City of Portland, Maine - Building or Use Permit Application

Location of Construction: 273 Presumpscot St	Owner Name: C & N Properties Llc	Owner Address: Po Box 1838	Phone:
Business Name: Haskell & Hall	Contractor Name: RDB Construction, Inc	Contractor Address: 155 Center Street Auburn	Phone: 2077836339
Lessee/Buyer's Name	Phone:	Permit Type: Additions - Commercial	Zone: I-M

RE: Review Comments for Final Plan – Administrative Review

Project Name: 273 Presumpscot Street; Addition of Second Story Office Space
Project ID: 10-79900036
Project Address: 273 Presumpscot St **CBL:** 420 - B-005-001
Planner: Shukria Wiar

FIRST & SECOND FLOOR PLANS  
**A-1.0**

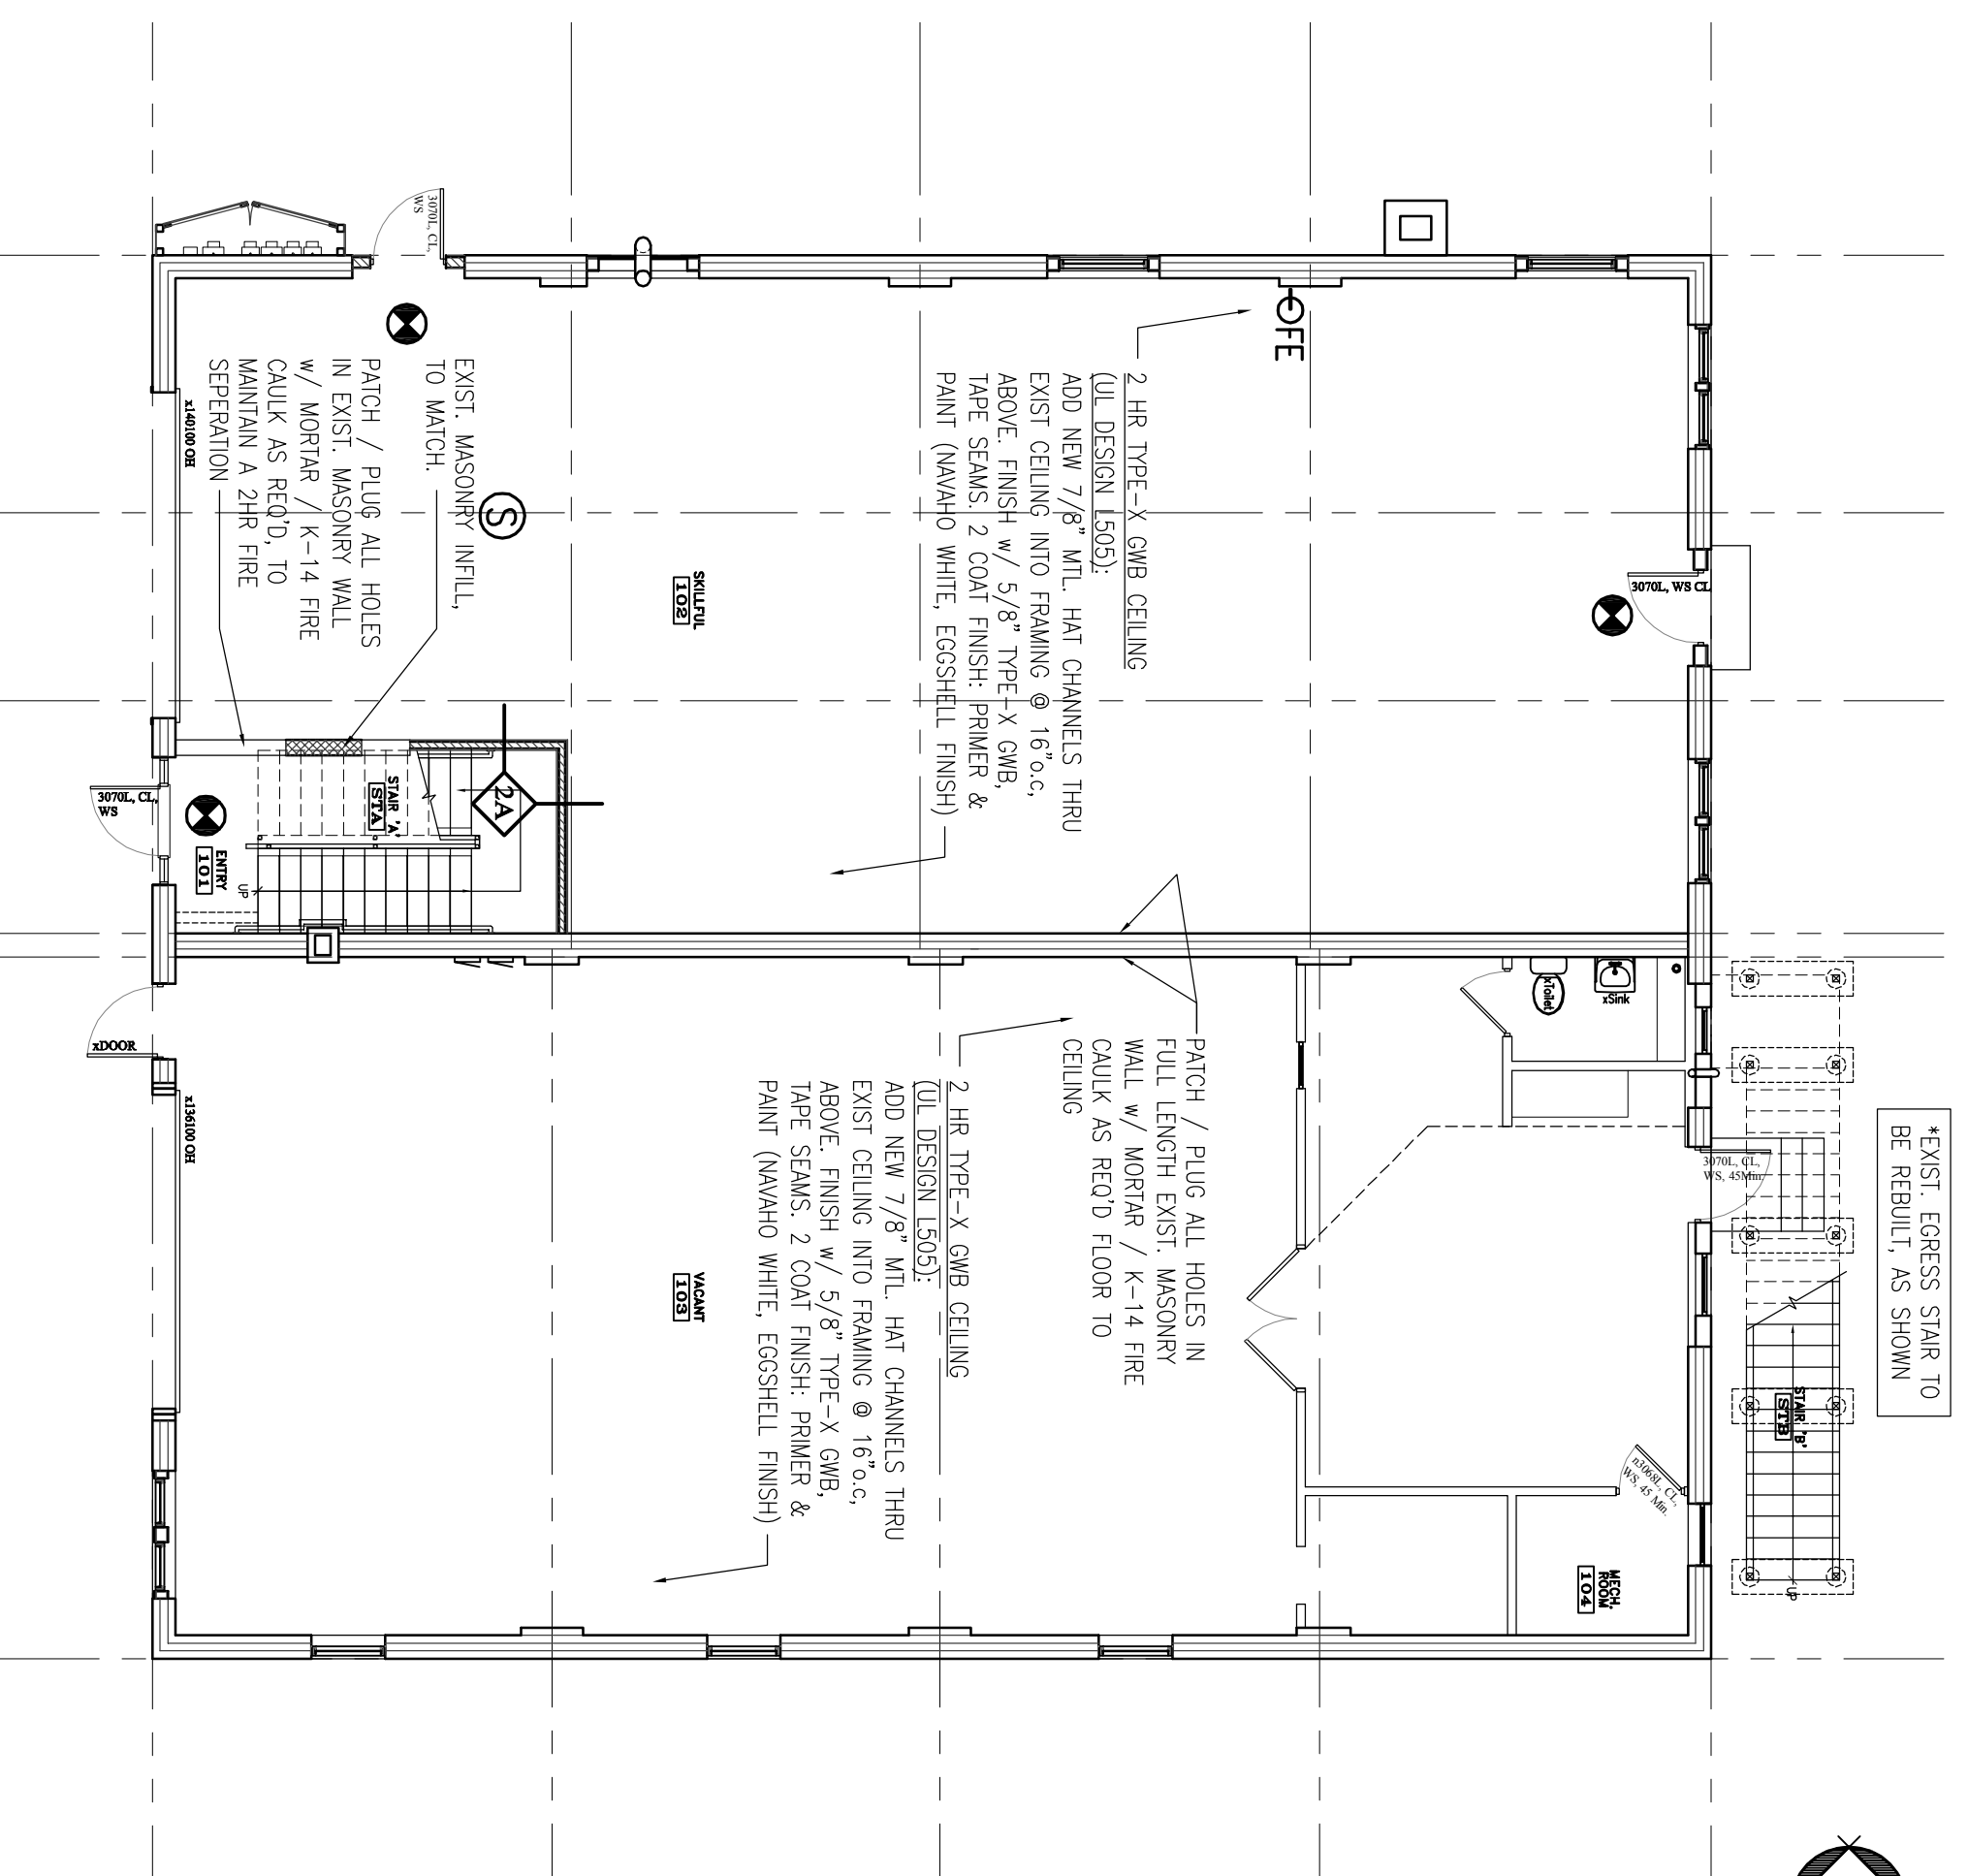
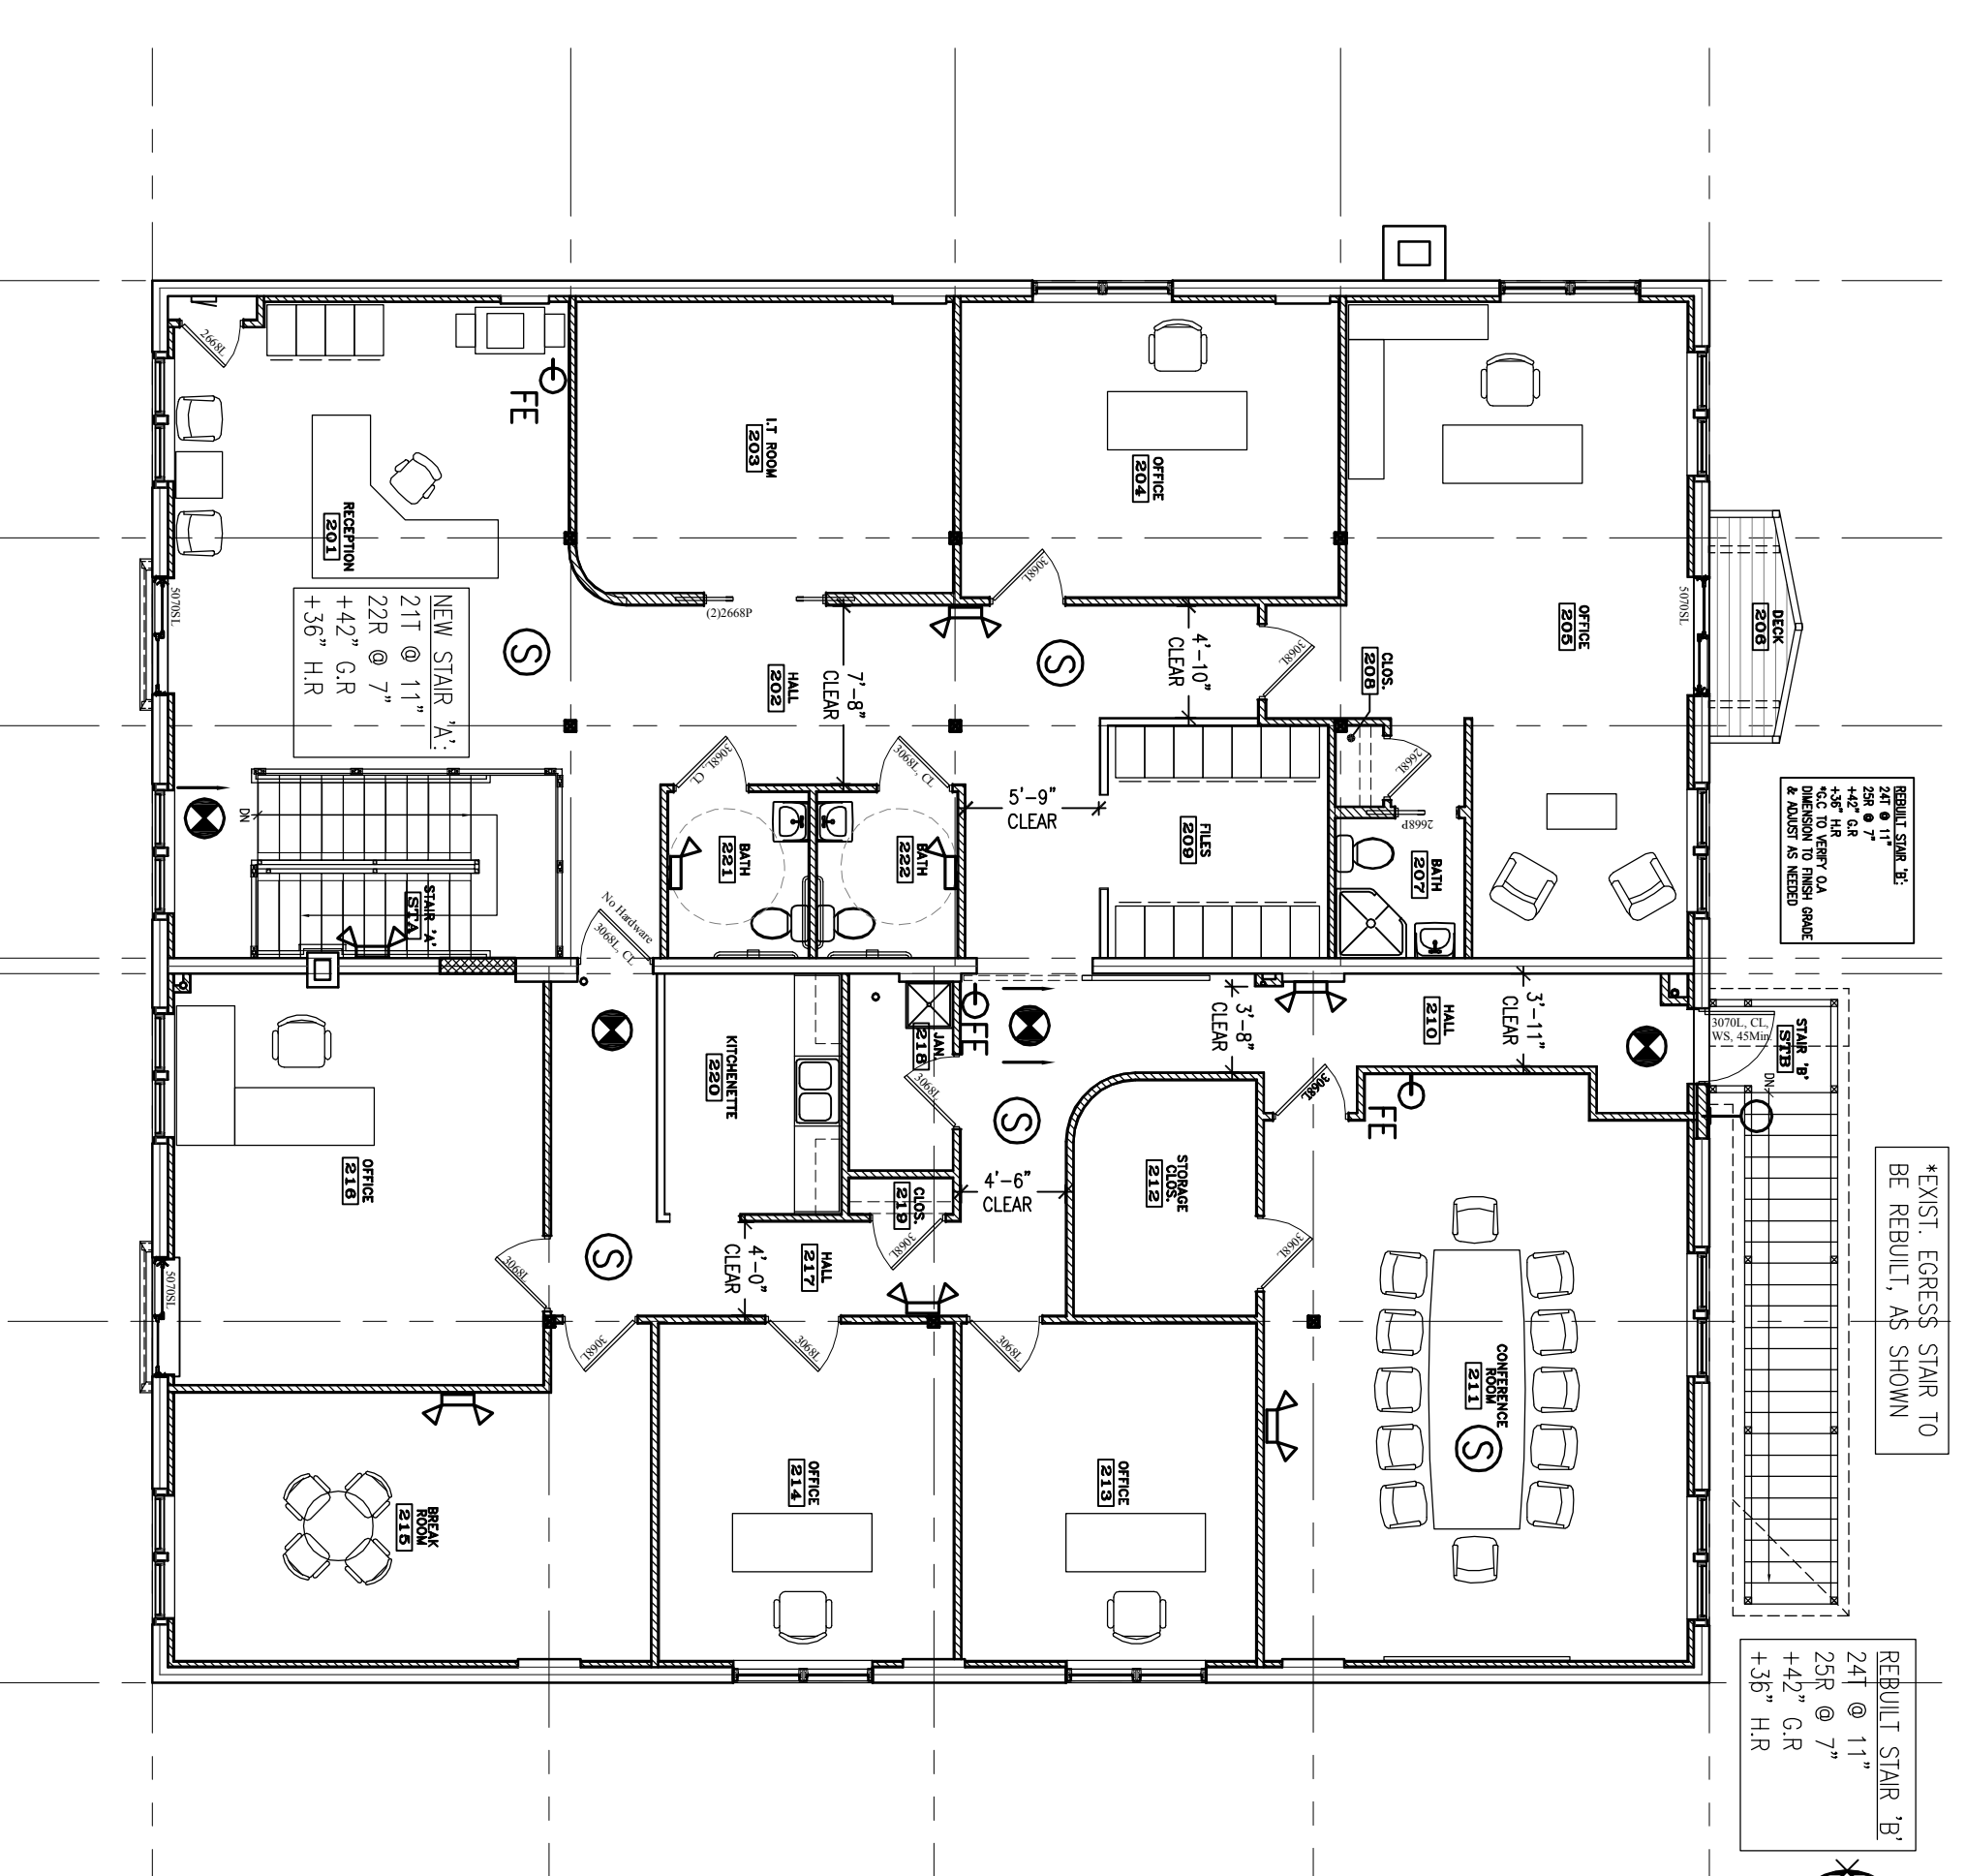
1) New Stairs shall comply with the current building code.			
2) Fire extinguishers required. Installation per NFPA 10			
3) All construction shall comply with City Code Chapter 10.
